Letter No. **A2/19257/2001**

Sub: CMDA - **Planning Permission - Construction of residential building GP at plot No.19, Manikkodi Srinivasa Nagar, Seevaram village - Development charges and other charges to be remitted - Reg.**

The Planning Permission Application received in the reference first cited for the construction of Ground Floor residential building at the above referred site at plot No.19, Manikkodi Srinivasa Nagar Seevaram village was examined and found approvable.

PLAN SHOWING THE PROPOSED RESIDENTIAL BUILDING AT PLOT NO-19, MANIKODI SRINIVASA NAGAR, SEEVARAM VILLAGE, SAIDAPET TALUK, VILLAGE NO-14A S.No. 18,19,20,30,31 & PART 14/2 B1

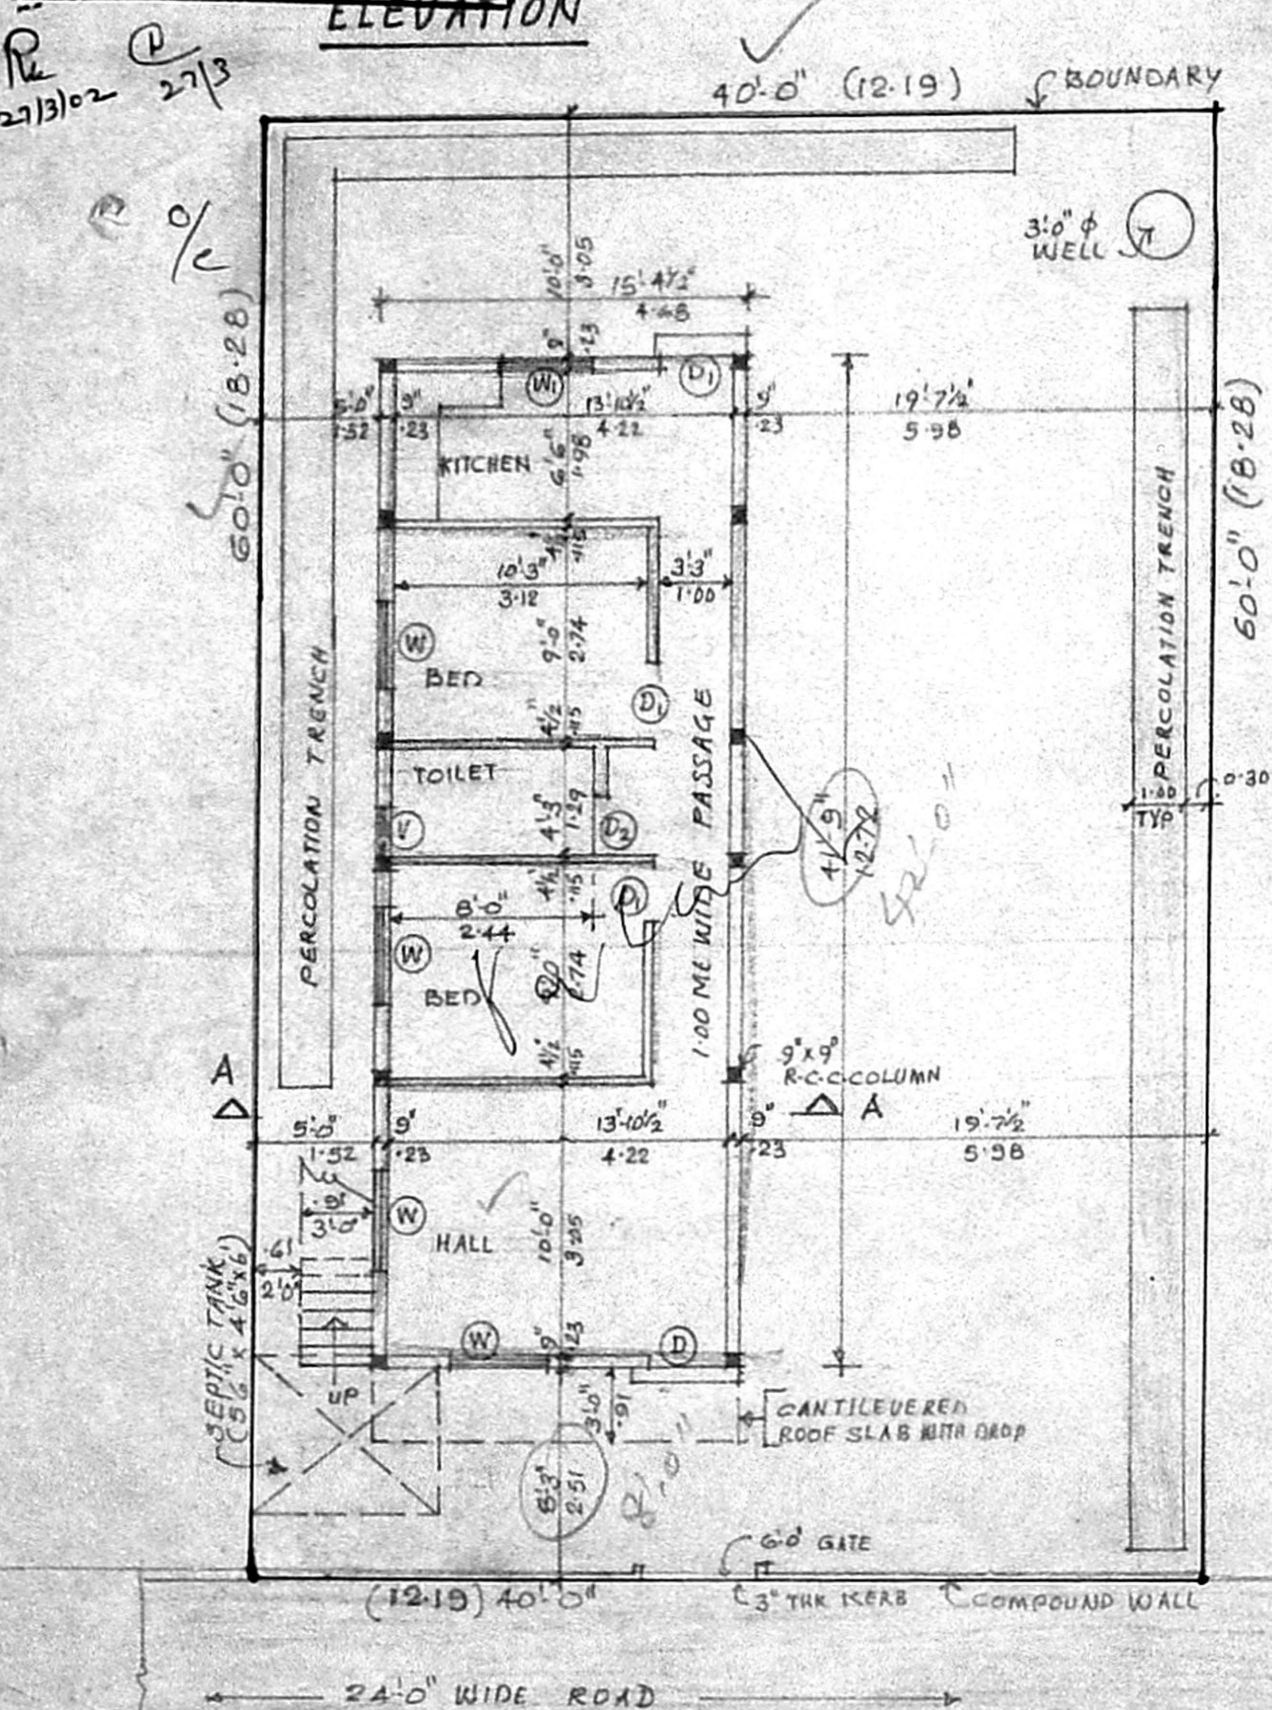
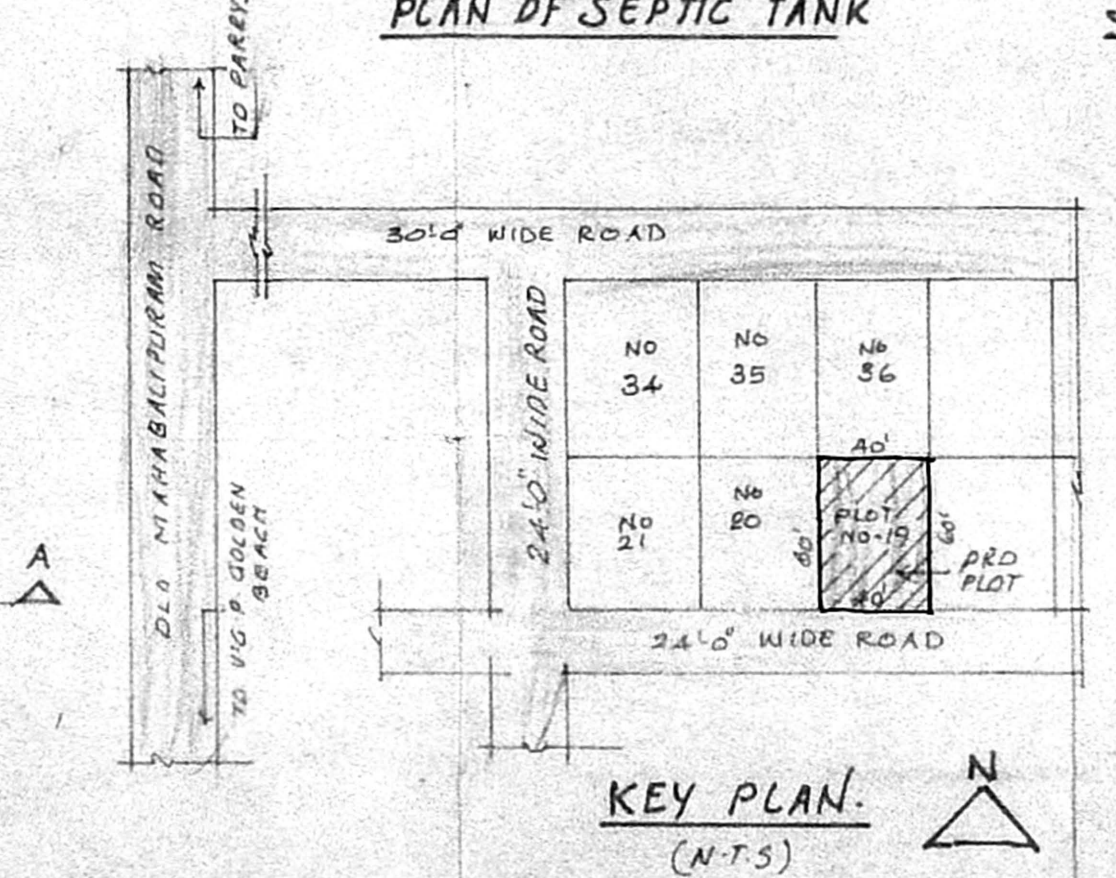
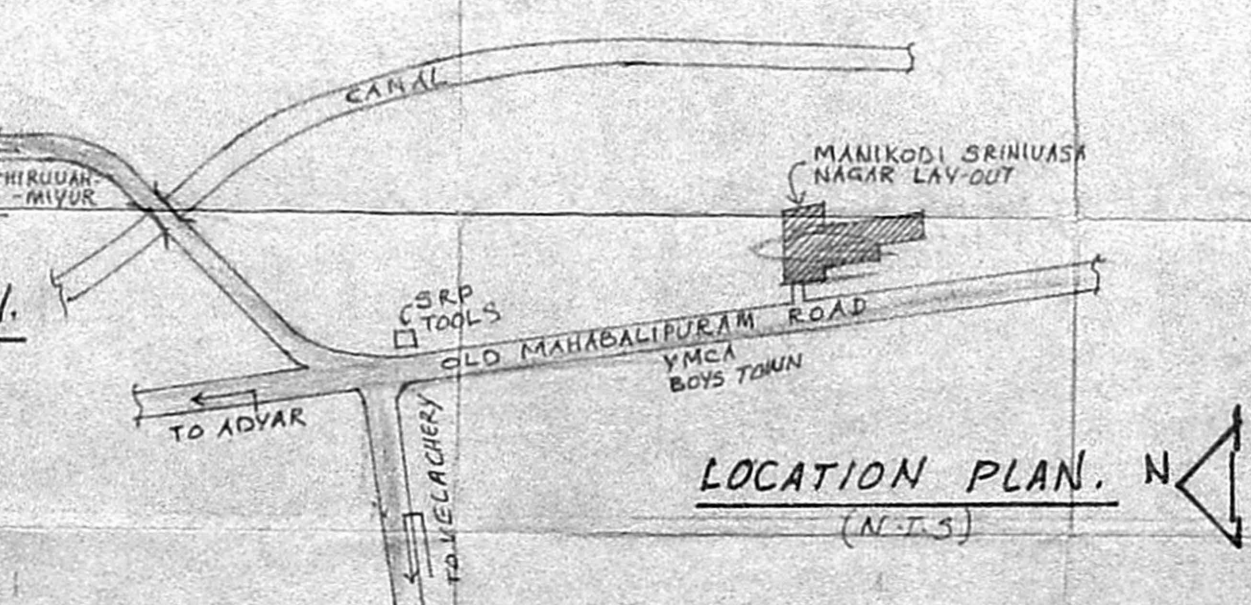
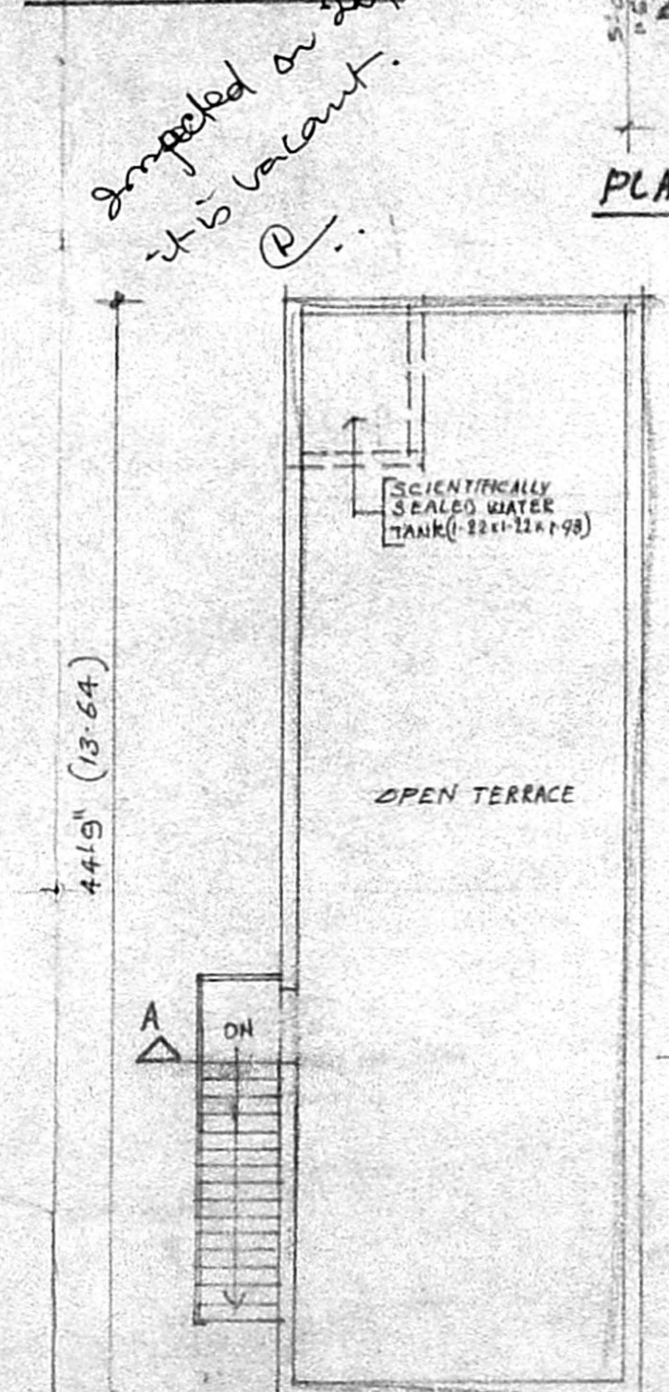
5. You are also requested to furnish Revised plan showing terrace plan details.
